COUNTY COUNCIL'S RESPONSE TO CONSULTATION ON THE FOLLOWING DEVELOPMENT PROPOSAL

Application no: 24/02058/F

Proposal: Full application for the proposed erection of a two storey building to form a 66 no. bedroom care home for older people with parking, access, landscaping and associated ground works.

Location: Land to the North of Anniversary Avenue, Graven Hill , Bicester, OX25 2BF

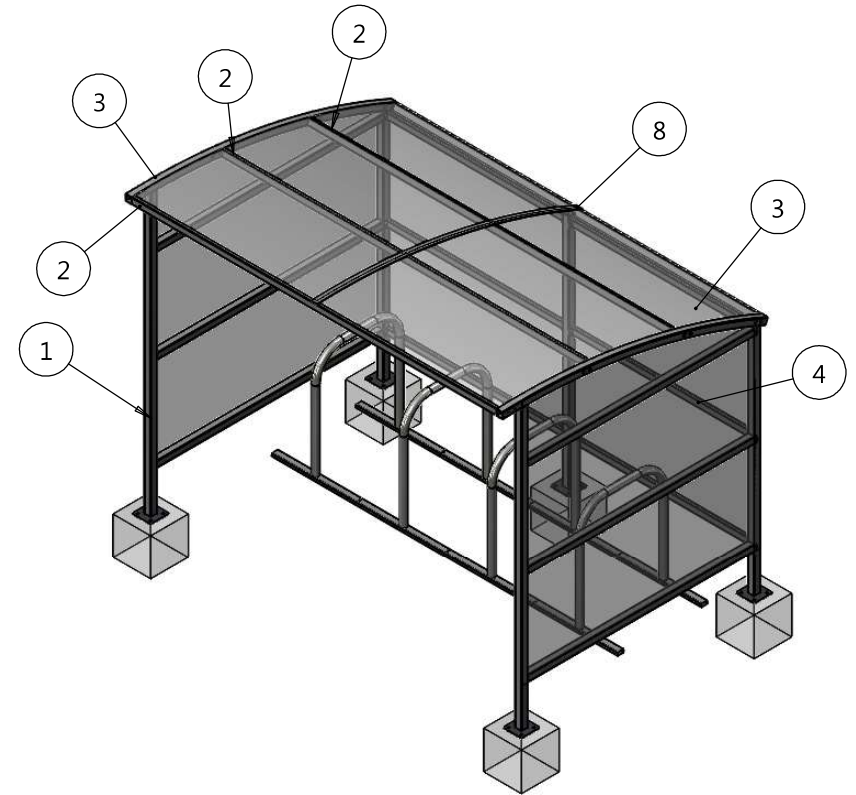
The application has only made provisions for staff parking of up to 4no. sheffield stands to accommodate 8 bicycles. This is insufficient in line with Oxfordshire County Council

TITLE
 PROPOSED SITE PLAN

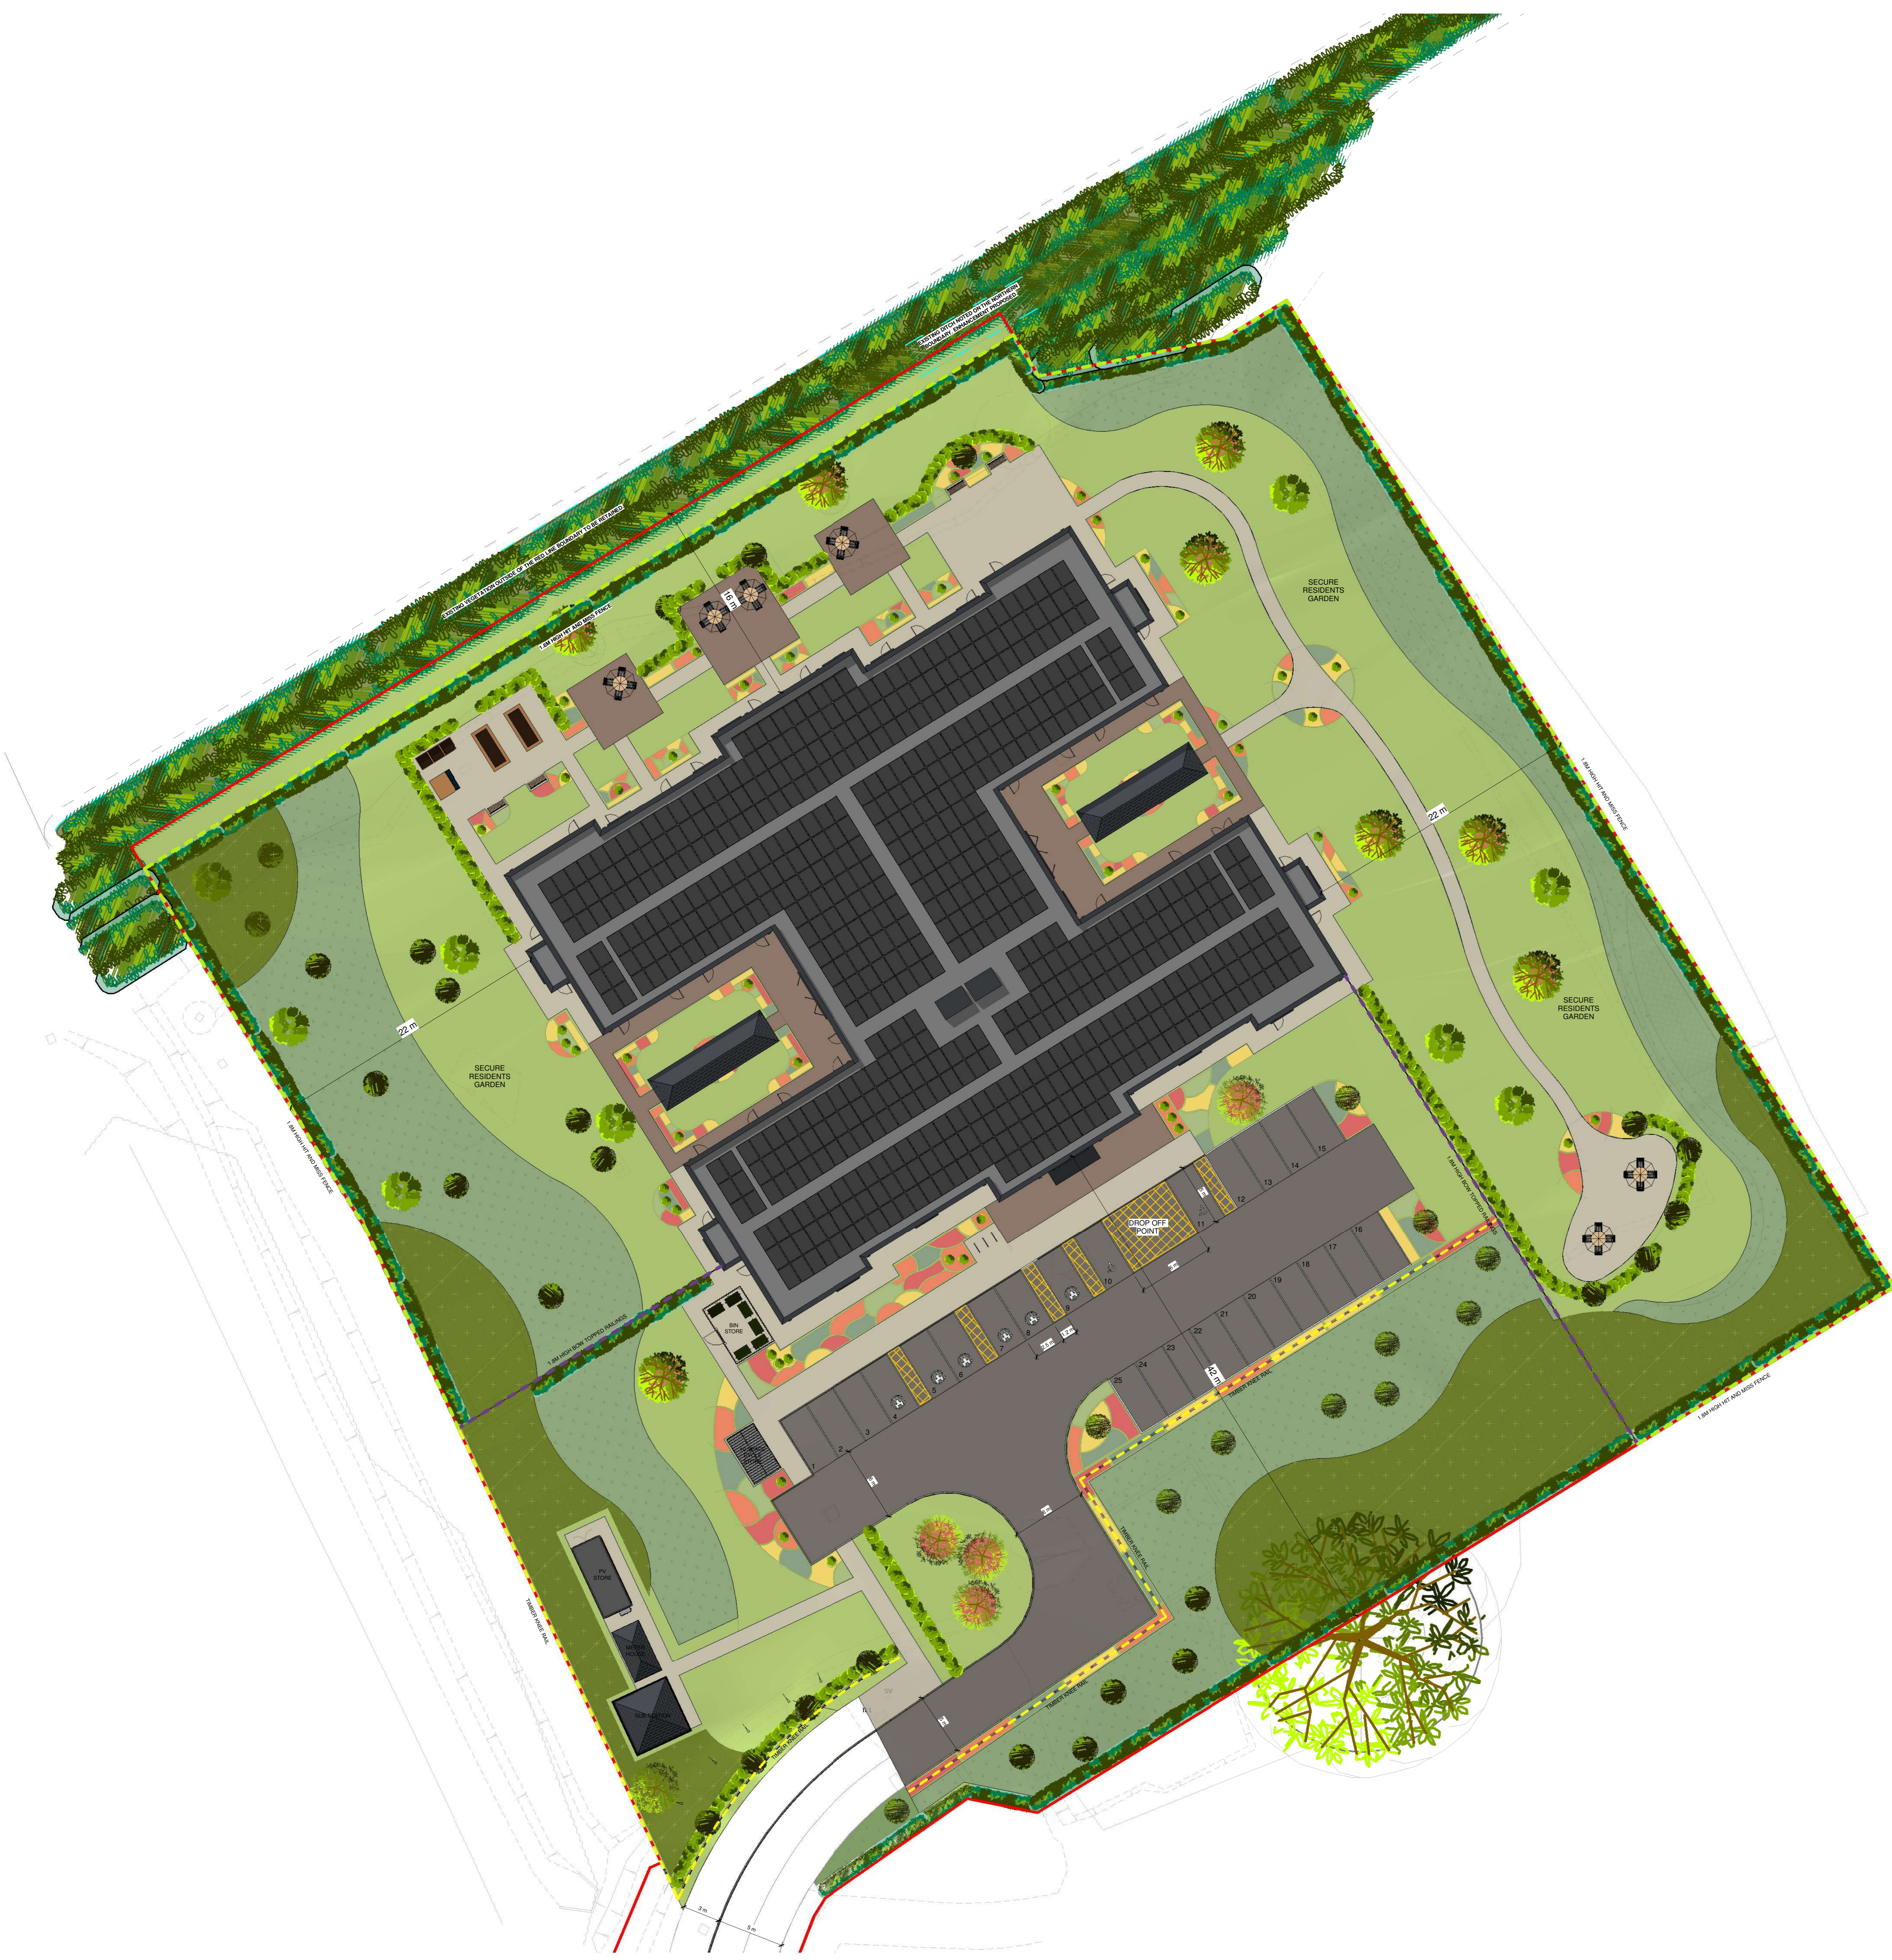
The application has not submitted a detailed access arrangement to enable us appraise its suitability. The dimensions of the carriageway or associated footways between Anniversary Avenue are unknown. Also, this arrangement has not been supported by a swept path analysis to ascertain whether certain vehicles can safely access the site.

Parking Standards that require up to 0.5 spaces per bedroom available to residents, visitors, and staff. **(Reason for objection)**

The application must endeavour to make separate provisions for visitors preferably closer to the building entrance. Both staff and visitors should be provided with a higher number of cycle parking to assure them there will be space to park their bikes when they arrive. This will make cycling a much more attractive option, especially once Graven Hill is fully built out as cycling will be an obvious option for these residents. As cycling is expected to increase in Bicester in the coming years, it is also important to improve this to prevent an unsightly overspill of bicycles parked and secured in locations where they later become an issue for pedestrians and other highway users.

In addition to the parking requirements, parking and turning areas for ambulance, mini bus and deliveries must be considered as well taking account of the varying dimensions of these vehicles. The hatched drop-off area immediately outside the main building entrance may seem sufficient for taxis and private cars but may not be sufficient for ambulances or special accessible vans that usually require an extra 2m for bed/ stretcher transfers. Such design requirements must be considered and appropriate revisions made.

TITLE
Drainage Strategy

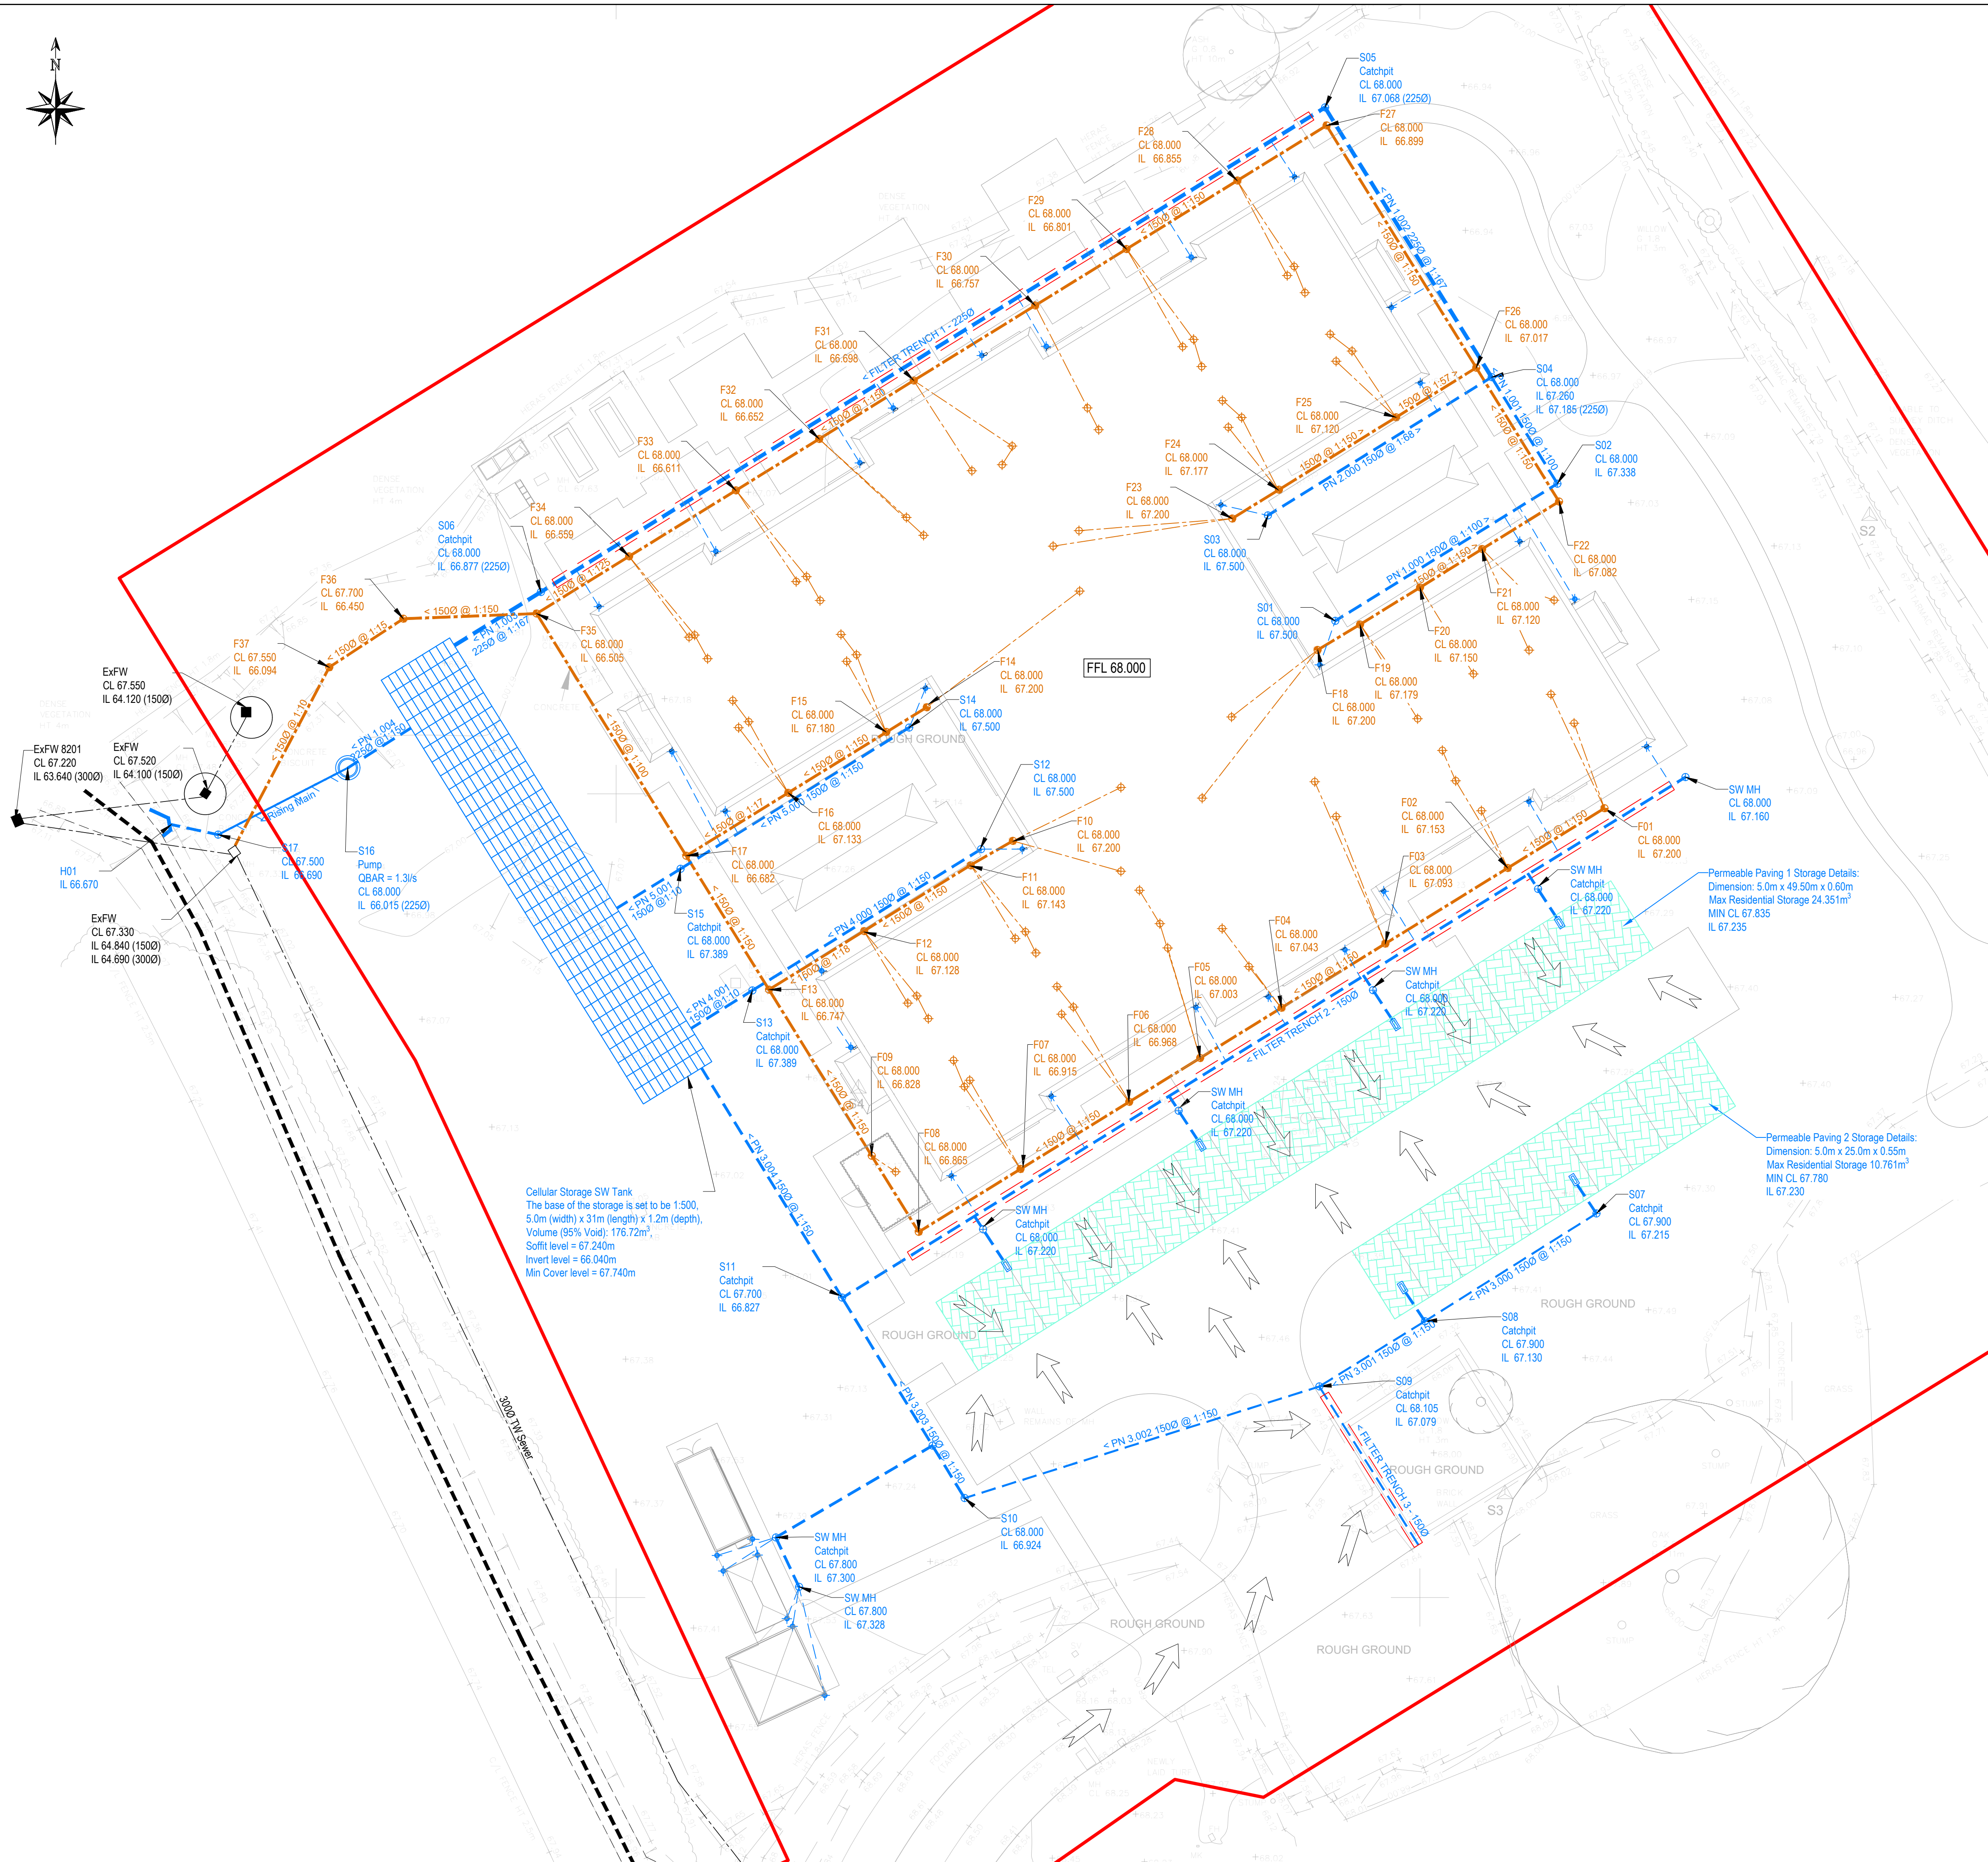
- Evidence of the allowable discharge rate above greenfield runoff rates should be included in the submission.

Infiltration has been investigated, however test results show that infiltration to ground would not be a viable drainage strategy. A watercourse is available at the boundary of the site. The proposal is to attenuate runoff and discharge to this watercourse at a restricted rate. Greenfield rates have been calculated for the site area. The proposed impermeable area appears to be much less than this. The specified discharge rate is greater than Q_{bar} for the whole site, and is stated to be an agreed rate from the 2015 site-wide drainage strategy. No further details have been provided on this strategy, therefore evidence of the approved allowable rate is required for this application. This could be provided as an excerpt from the drainage strategy referenced, along with details of the strategy approval.
